Our Ref: R/215/17/PL

**Town & Country Planning Act 1990 (as amended)
Town and Country Planning (Development Management Procedure) (England) Order 2015
Application for Planning Permission**

Development 2 No. employment units for Class B1 (B1 Business) and/or Class B8 (B8 Storage or Distribution) with ancillary trade counter & office (Class B1a) together with associated access, car parking & landscaping

Location Units 6 & 7 Brookside Avenue Rustington

Proposed Redevelopment
Units 6 & 7
Brookside Industrial Estate
Brookside Avenue
Rustington, West Sussex
Site Plan

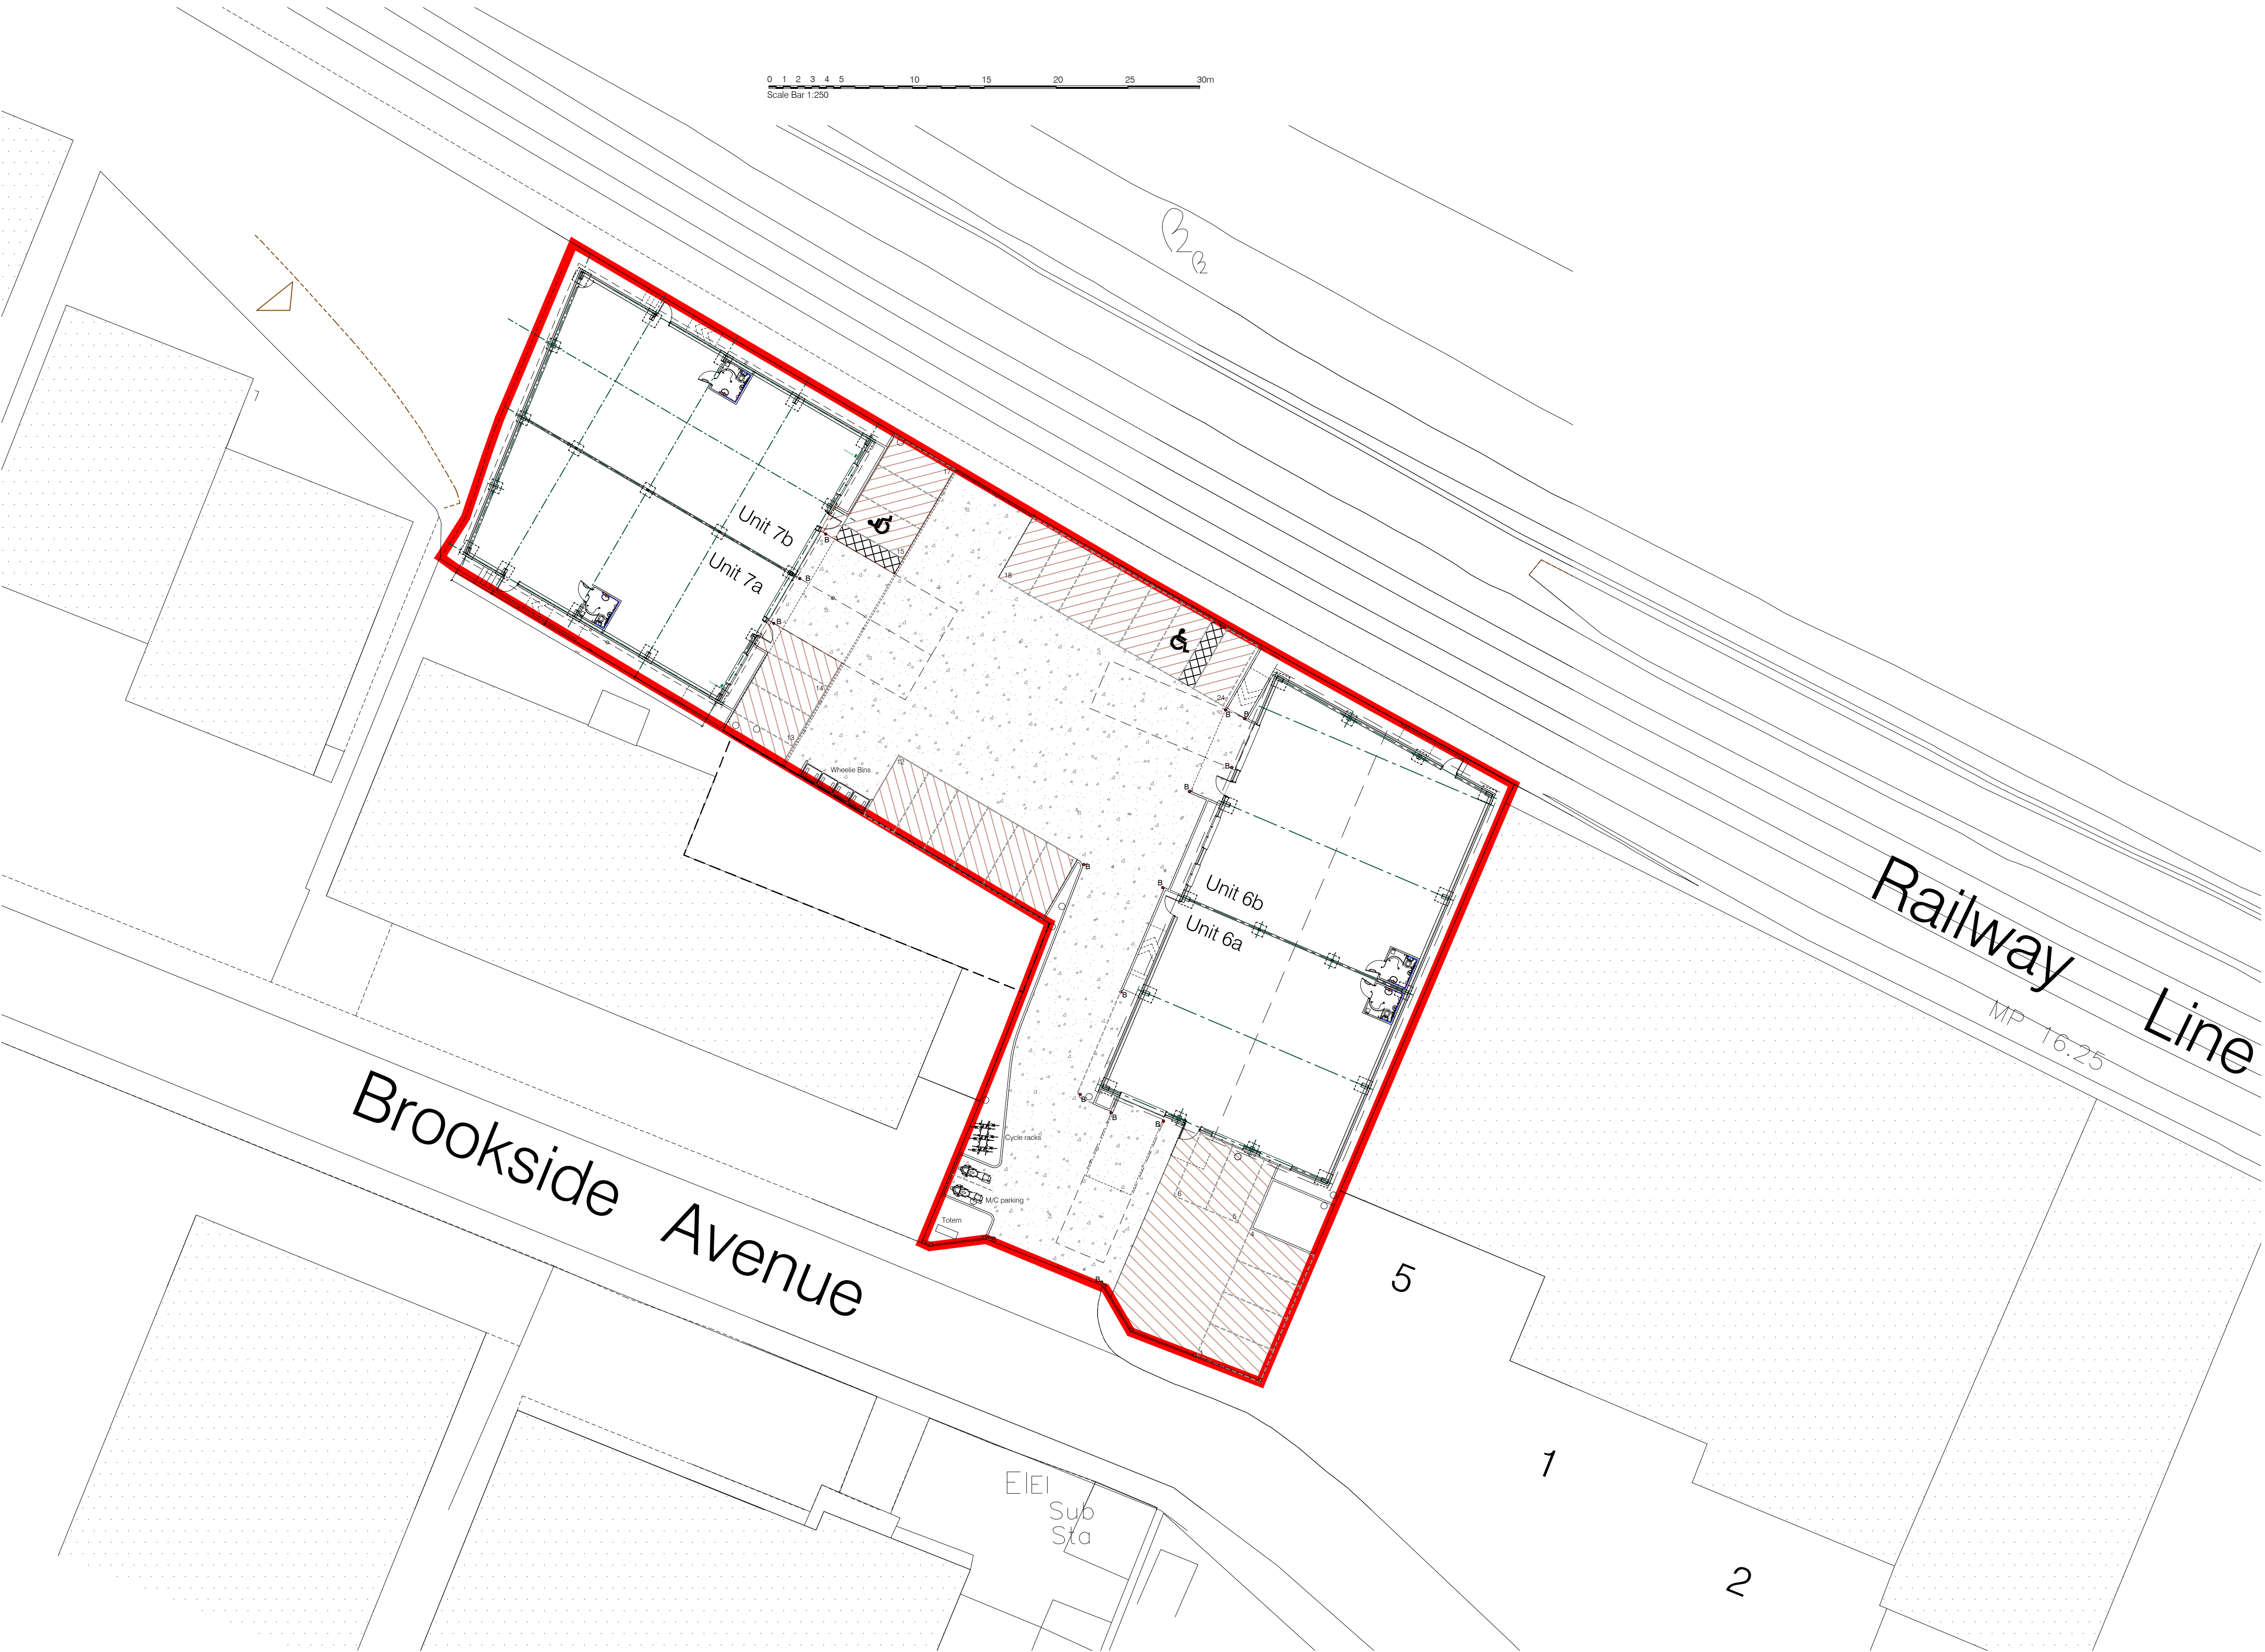
Bin Storage and Collection Provision

This application requires the provision of bin storage/collection facilities. Please provide details in the format as set out in the Local Validation Requirements so that Environmental Services are able to assess whether the proposal is acceptable.
